Bank Street Park
Blackwattle Bay / Tjerruing

SSD-53386706

Building Code of Australia Report (Philip Chun)

**PROPOSED BANK STREET PARK DEVELOPMENT
1A-19 BANK STREET, PYRMONT NSW**

Drawing number+ 346_SSDA_114
 revision 06

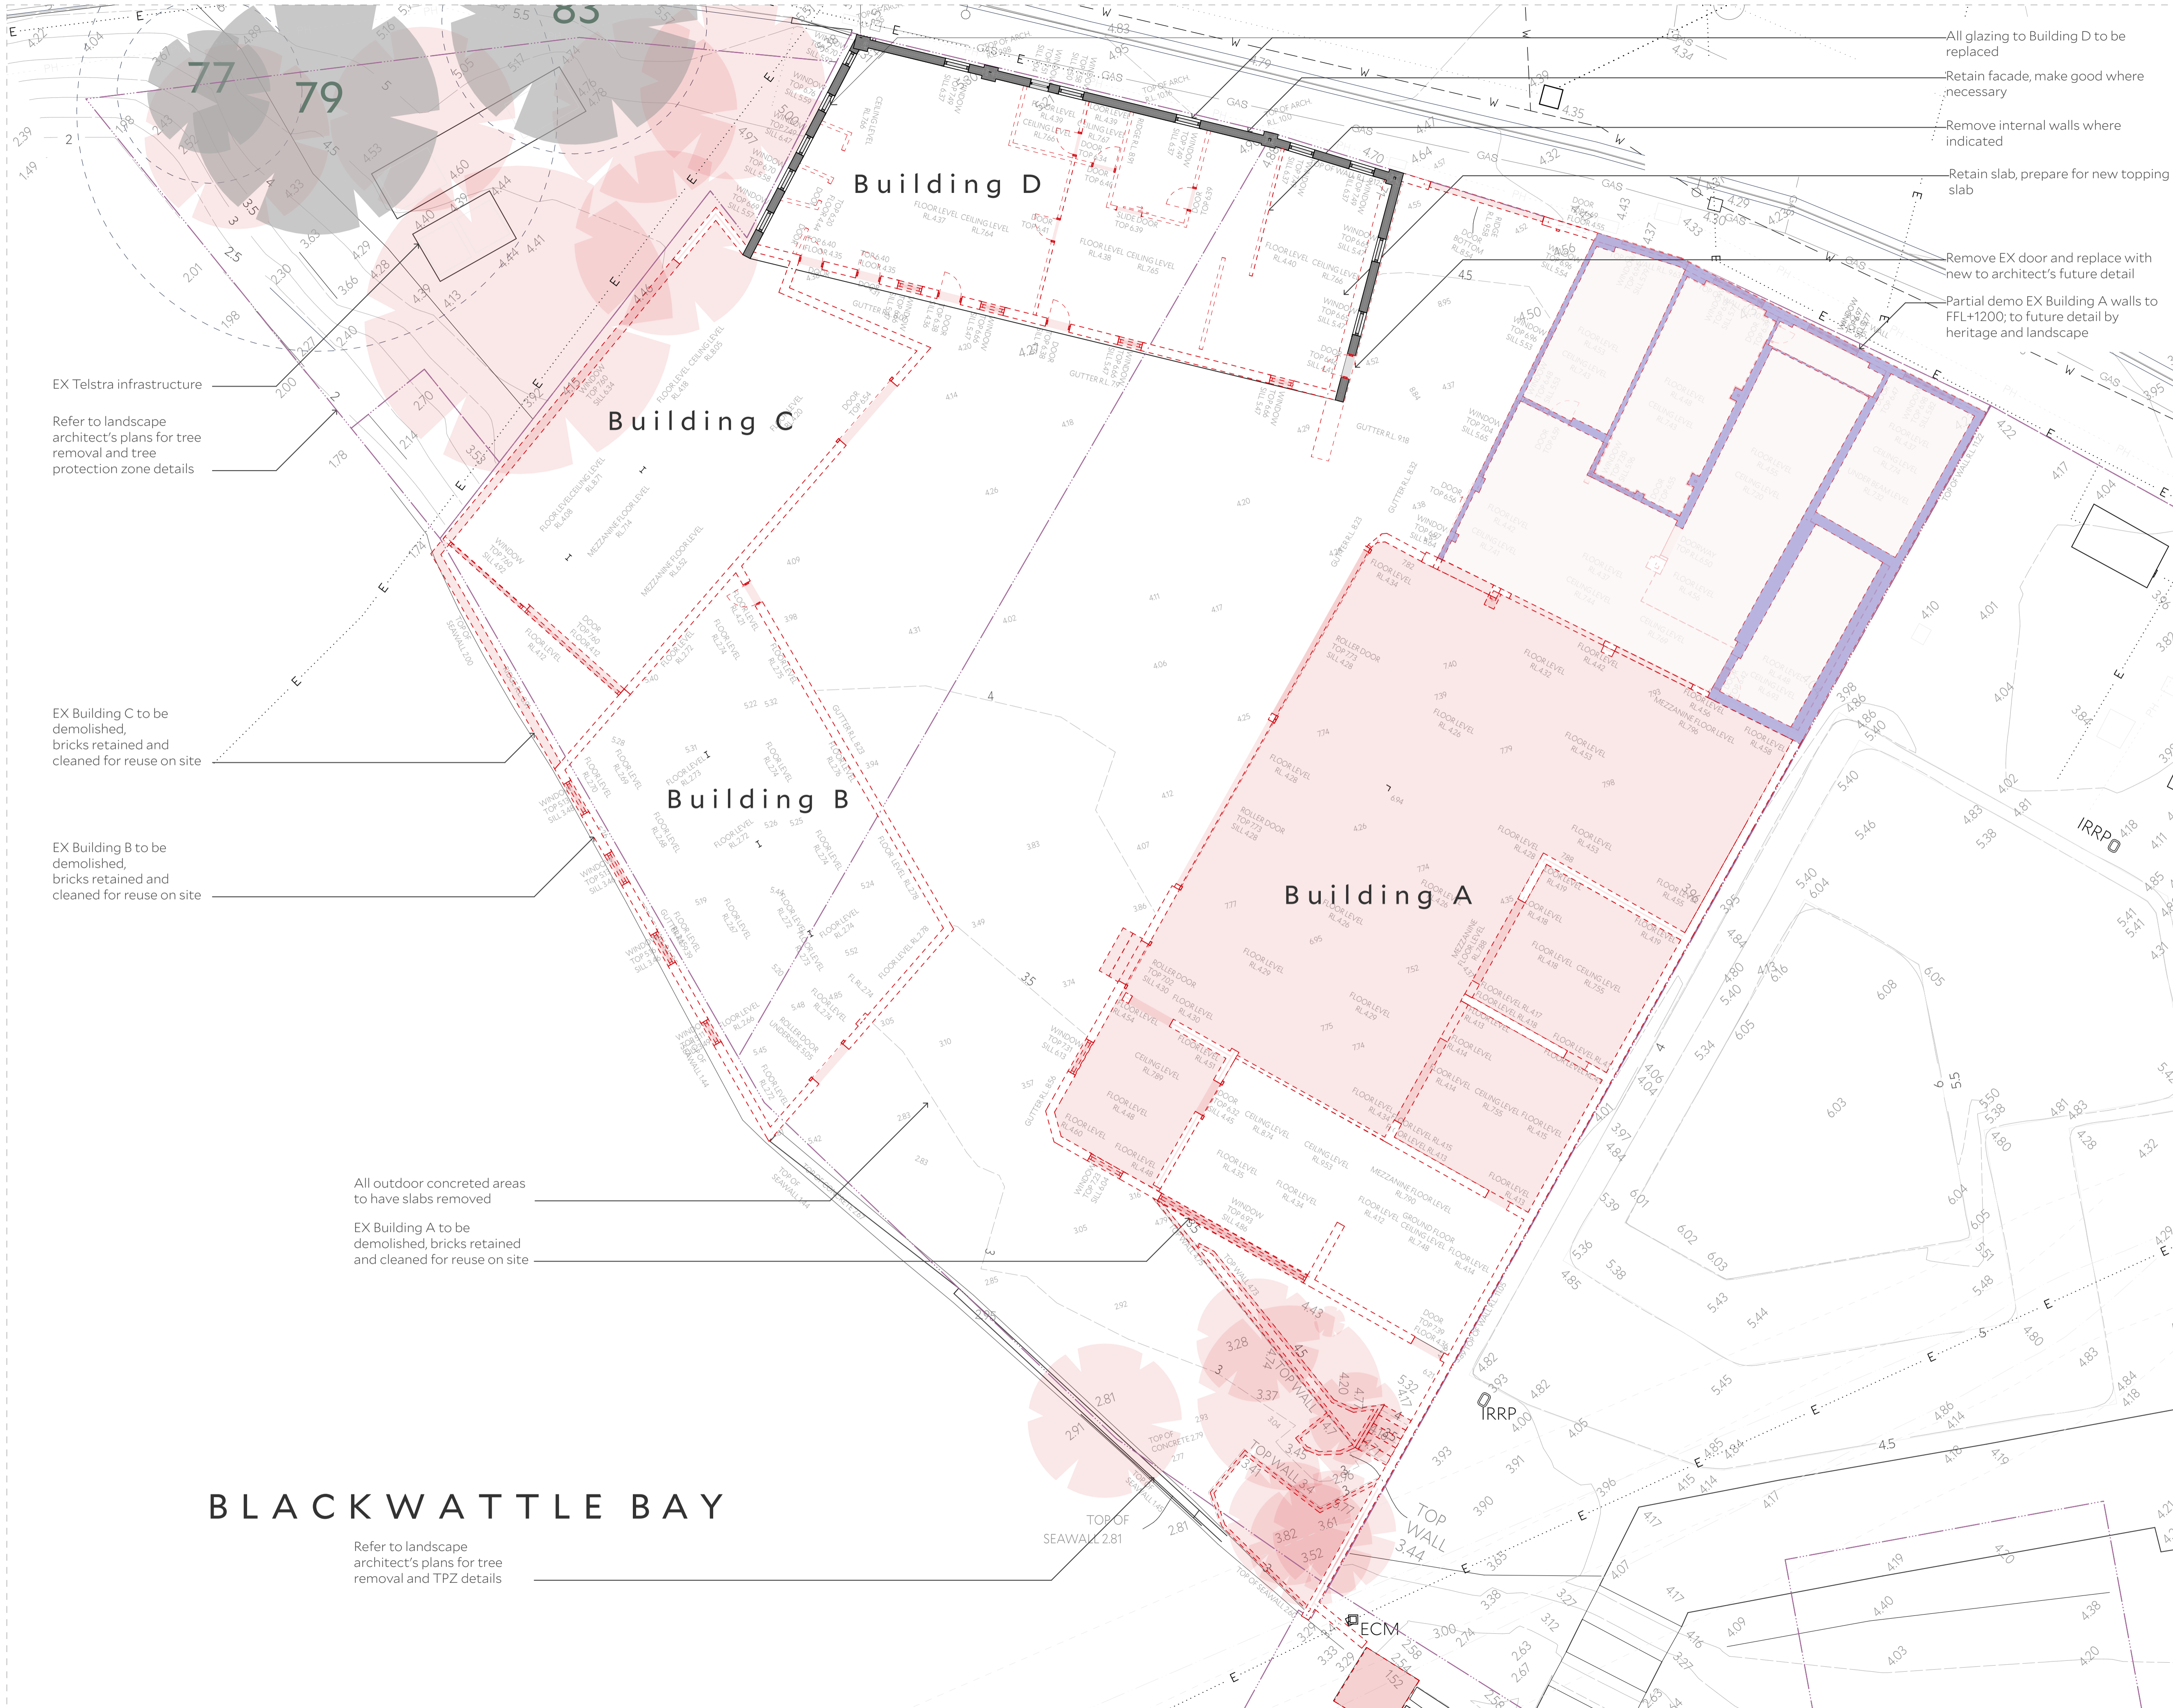
The north-western walls of the building that are within 3m of the side allotment boundary are to at least achieve an FRL of 90min or consolidate the multiple allotments. Details will need to be provided at CC stage to verify compliance.

The proposed windows within the north-western external wall of the building adjacent to the side allotment boundary are to be protected in accordance with C4D5 below or consolidate the multiple allotments. Details will need to be provided at CC stage to verify compliance.
